## **SDNP/24/00996/HOUS**

Address: Fern Bank Borden Lane Borden Milland West Sussex GU30 7JZ

Proposal: Outdoors swimming pool and pool building.

On Behalf Of: CH - Environmental Strategy

Tree Protection

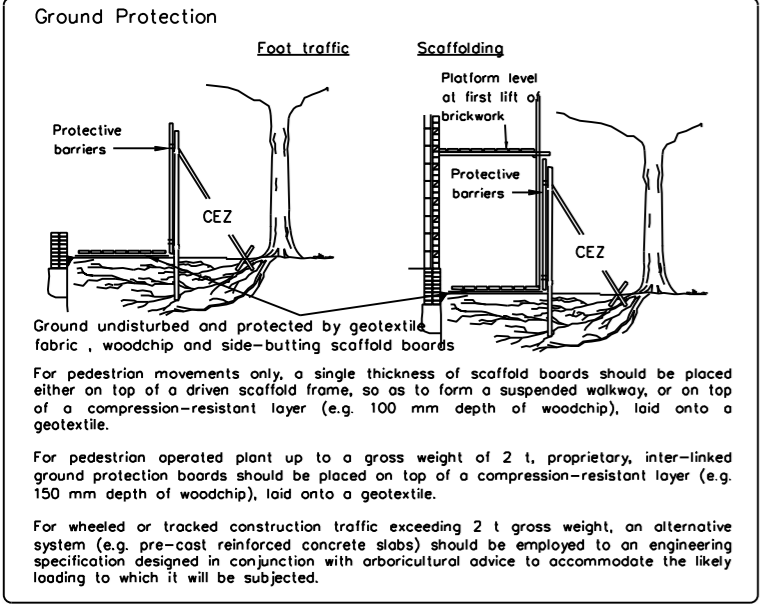
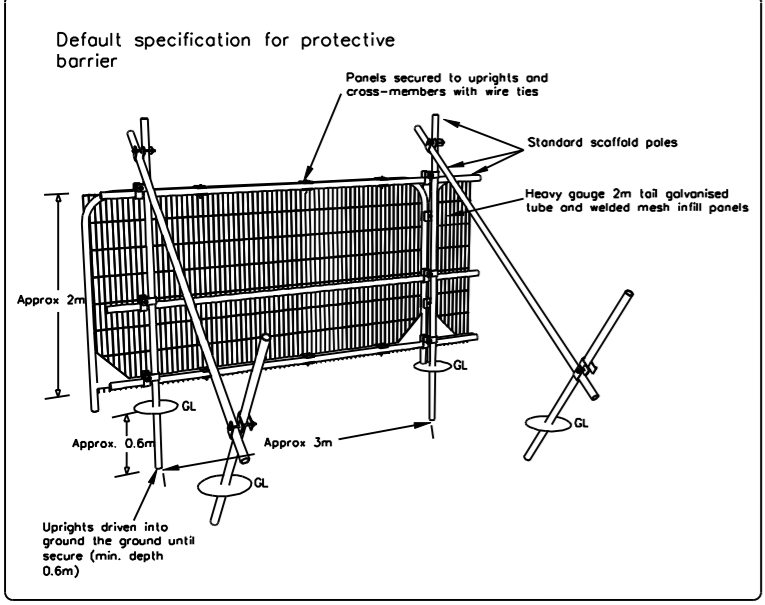
Due to the removal of a number of trees on the site we require that these are replaced elsewhere on the site.
